**Summary  
of  
Written Representation  
of the  
Kent Downs AONB Unit**

LOWER THAMES CROSSING PROJECT**

**KENT DOWNS AONB UNIT - Unique Ref 20035310**

*Local Landscape Character Area boundaries used in the ES, Chapter 7*

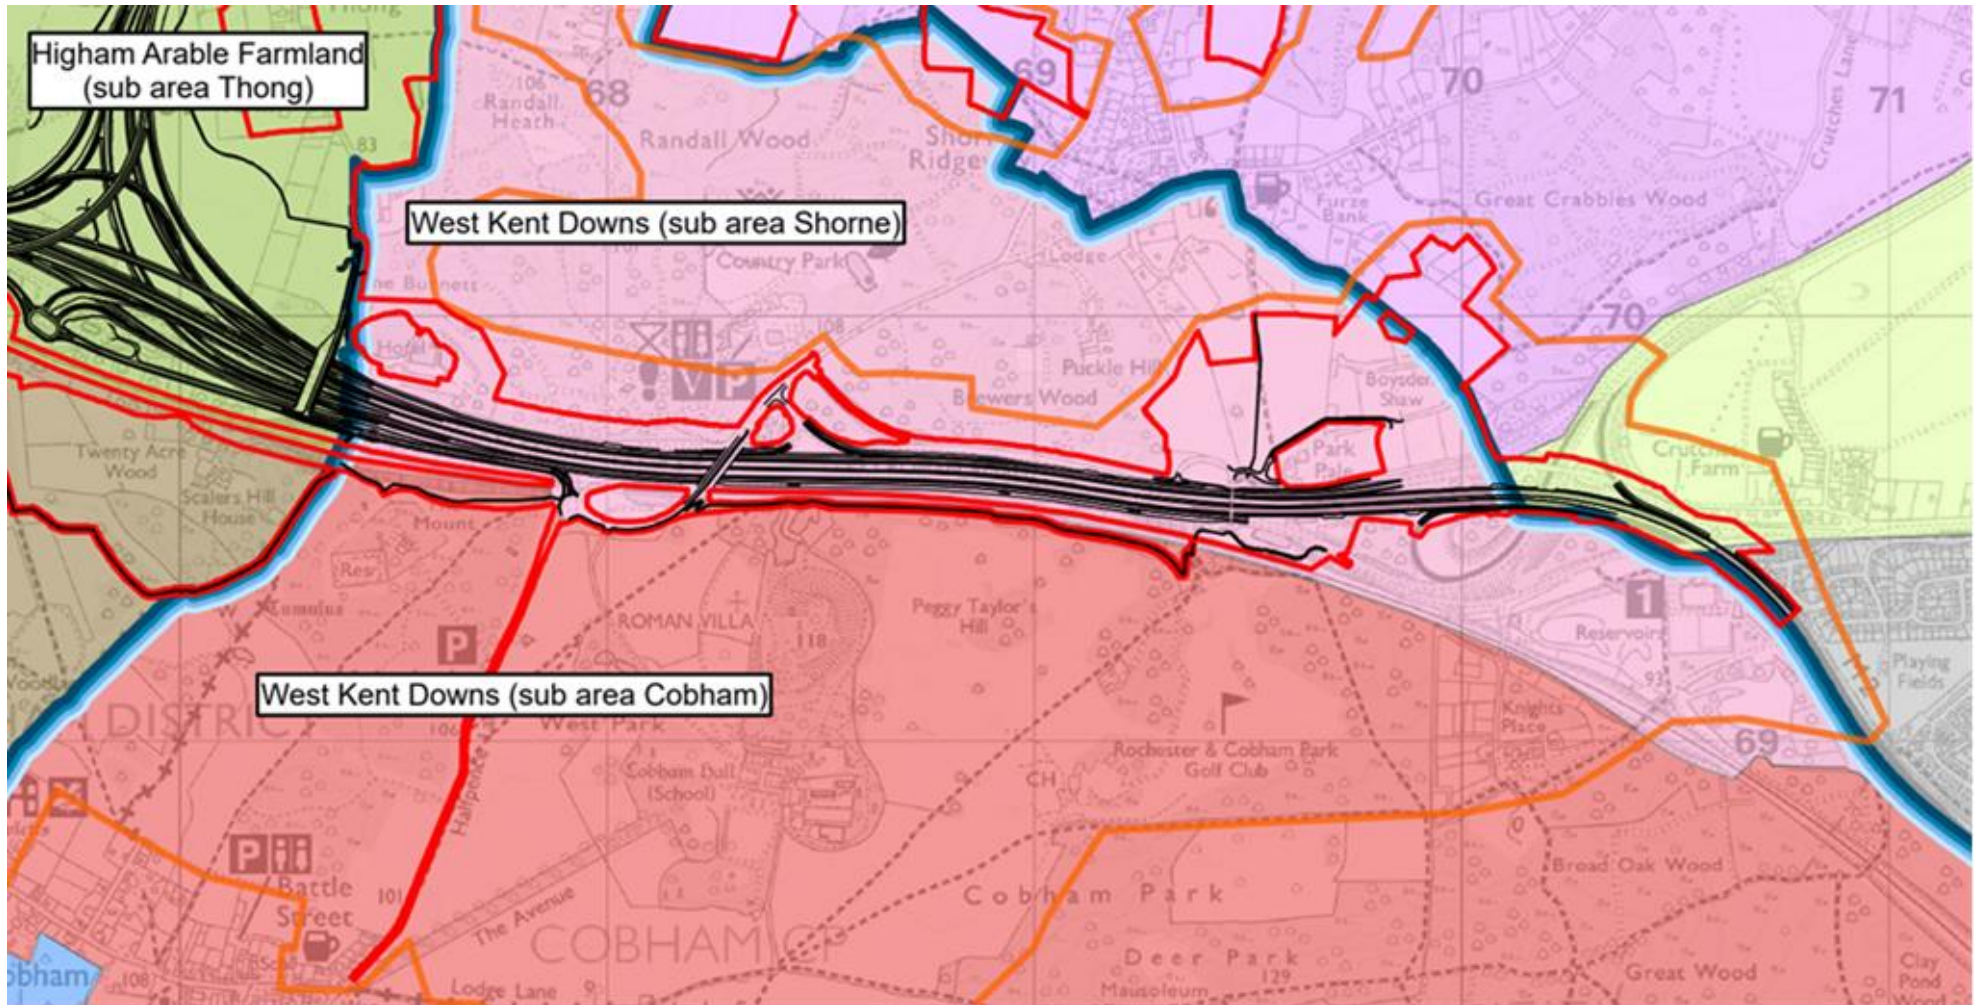
The Kent Downs AONB Unit considers that the impacts from the Project on the AONB are underestimated in many instances in the Environmental Statement, Chapter 7, as well as in the Planning Statement and its Appendix F. It is notable that the assessed level of impacts are downgraded, significantly in some instances, from the Environmental Statement accompanying the 2020 DCO submission and the current version, despite no significant change in the scheme and with no justification for the change provided in assessment.
